# Stormwater Detention and Infiltration Design Data Sheet

# Markup Summary

**PROPOSED LAYOUT**

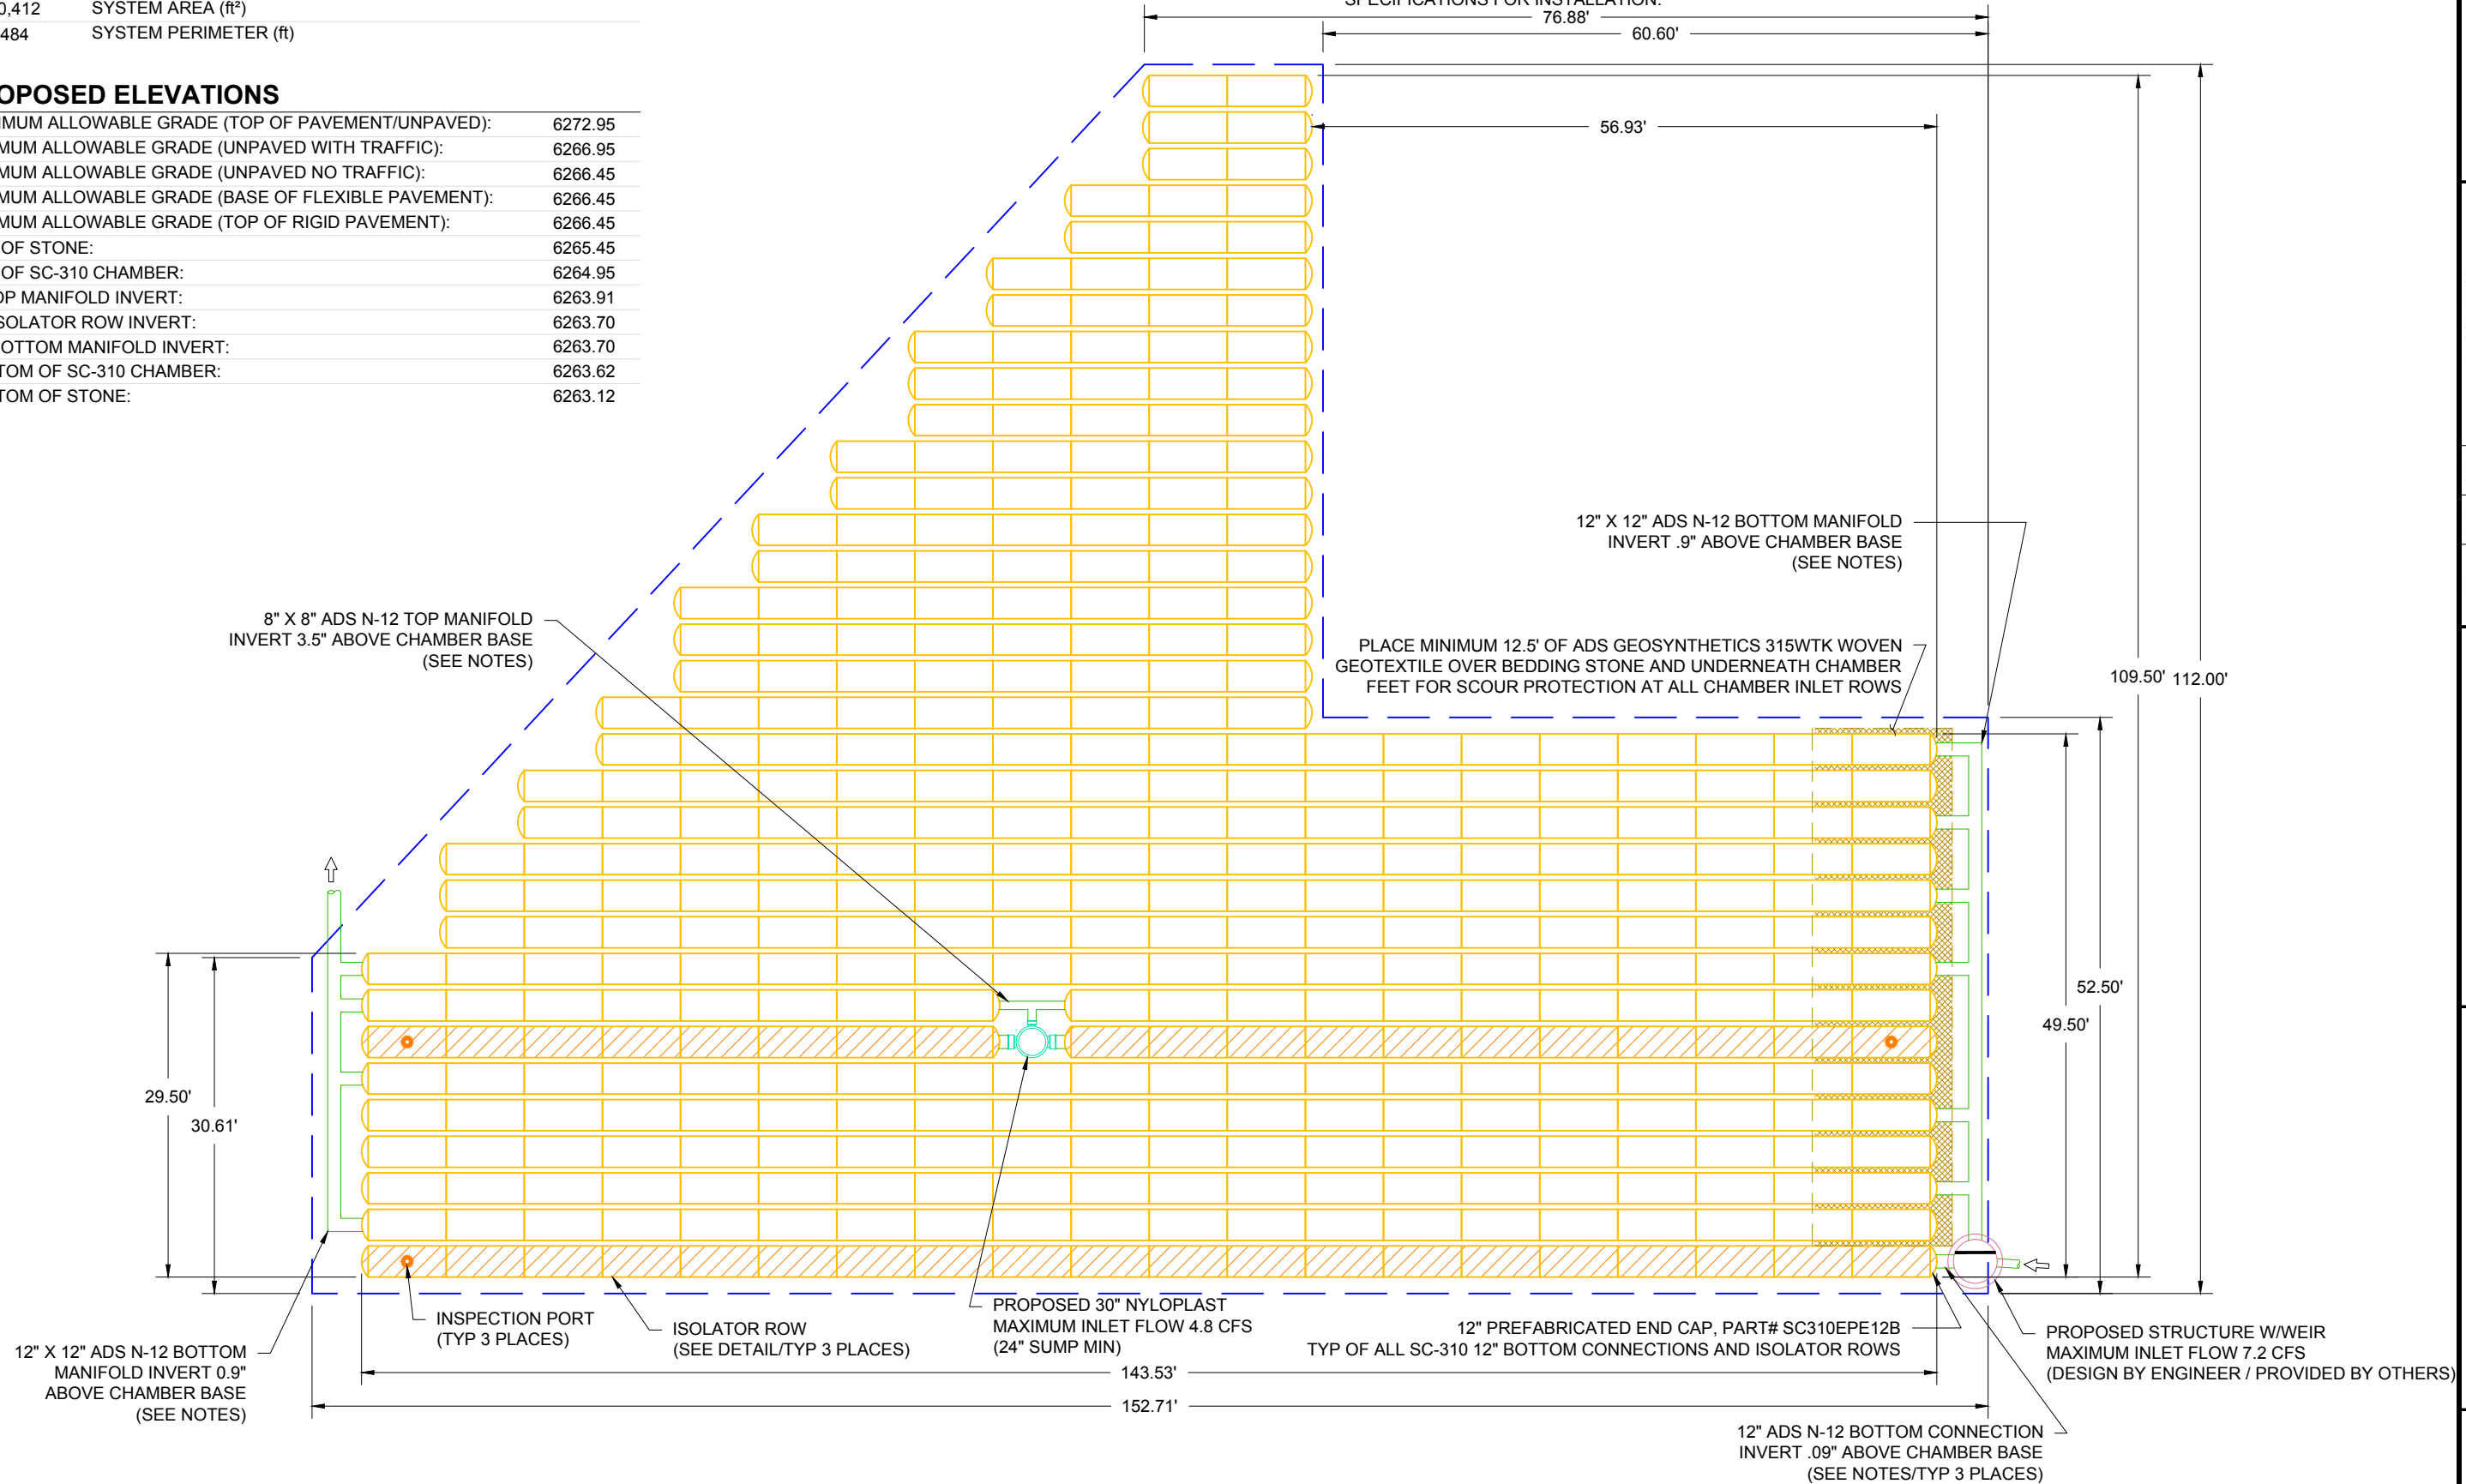
The underground detention should be modeled as Sand Filter with 12hr drain time.
